Application no: **3/2021/1127**

Address: **Pack Horse Garage Mellor Brow Mellor**

Proposal: **Variation of Condition 15 (approved plans) from planning consent 3/2016/0282 to allow alterations to retaining walls in the car park.**

Drawing Title	Proposed Overall Site Plan - G.A
Scale	1:200 @ A1
Date	Sept 2019
Drawn	Craig Harrison

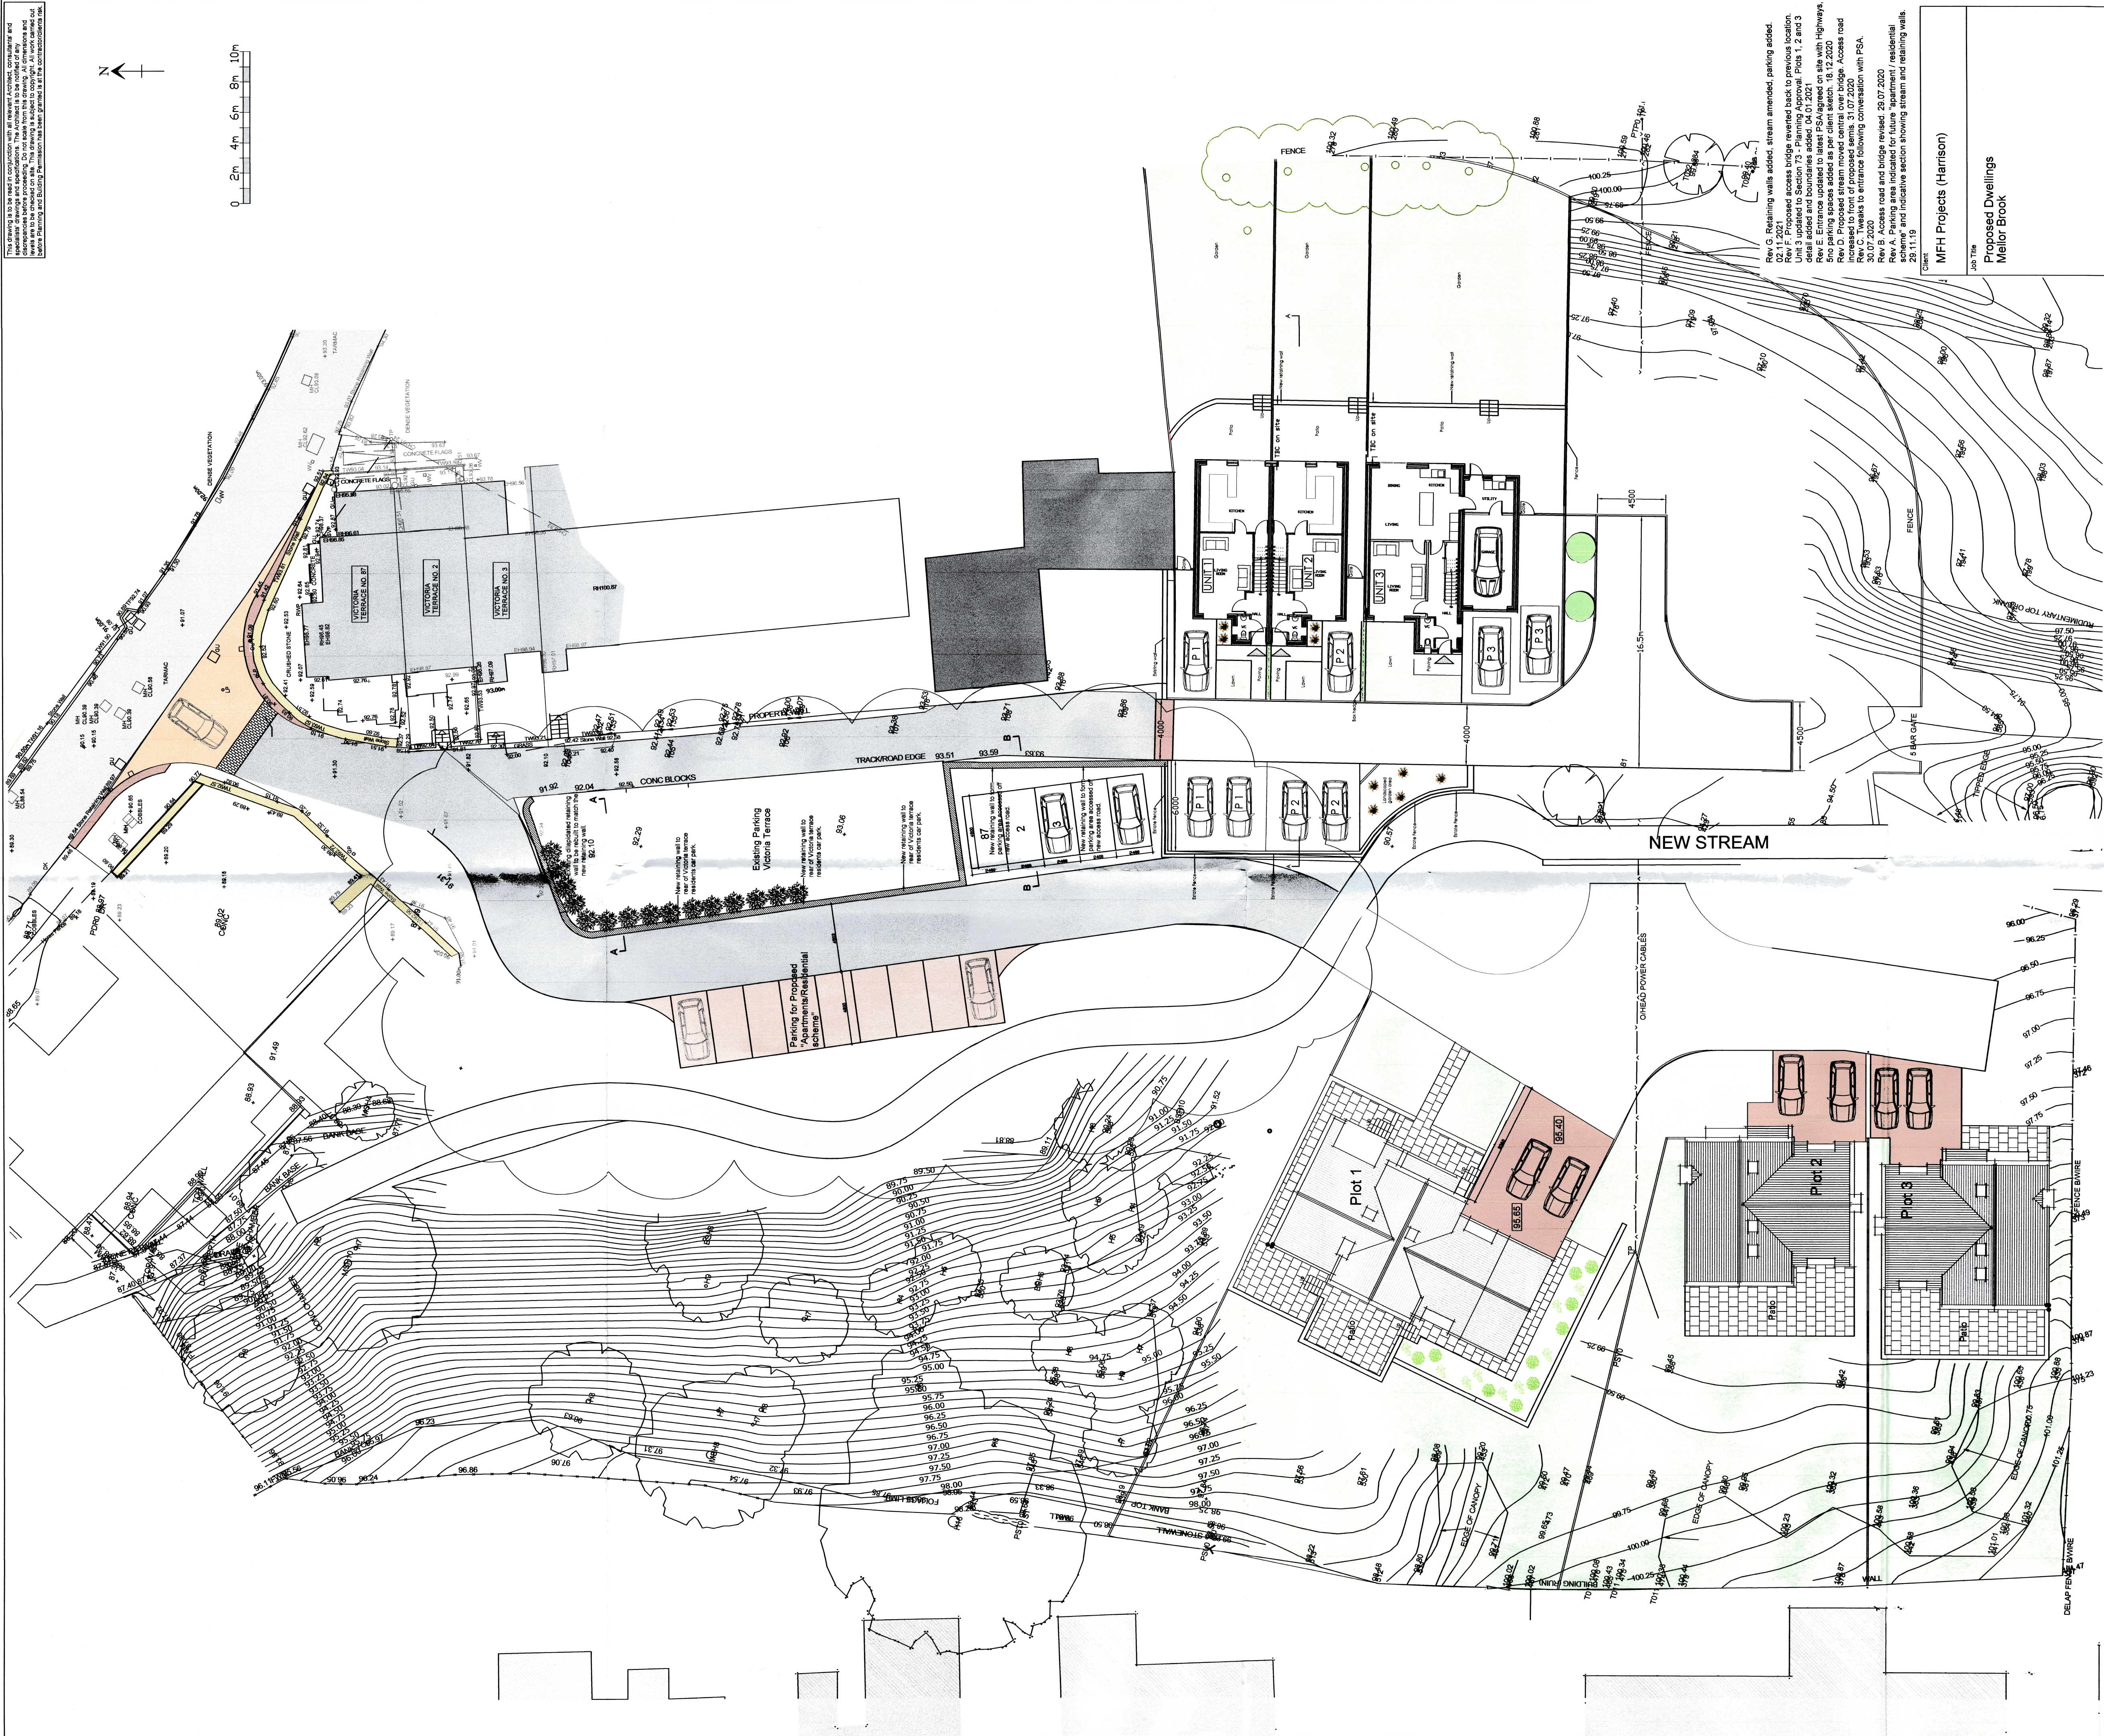
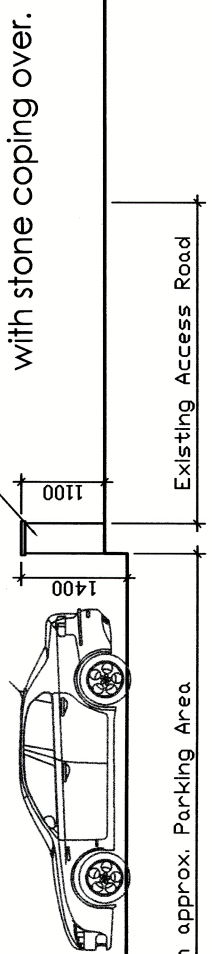
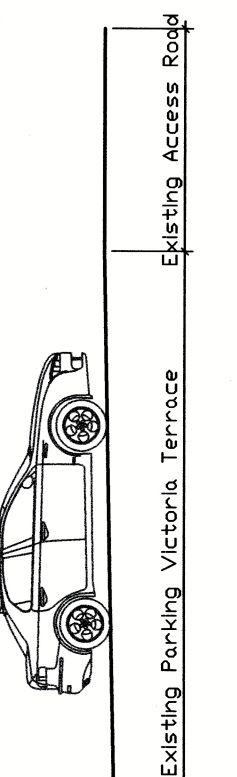
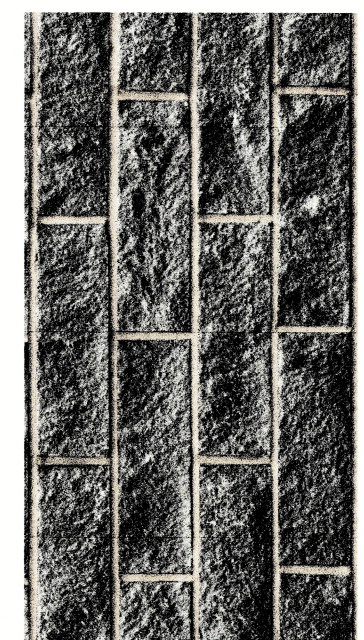
However, the LHA do require further information and so object against the alterations to the retaining wall fronting the adopted public highway on Mellor Brow to the left of the access.

For the LHA to support the alteration to this retaining wall fronting the public highway, the LHA require a cross-section and an elevation drawing of the proposed retaining wall to see whether the levels between the public highway and the retaining wall have changed.

The LHA also require information regarding the height of the retaining wall. This should be shown on the elevation drawing.
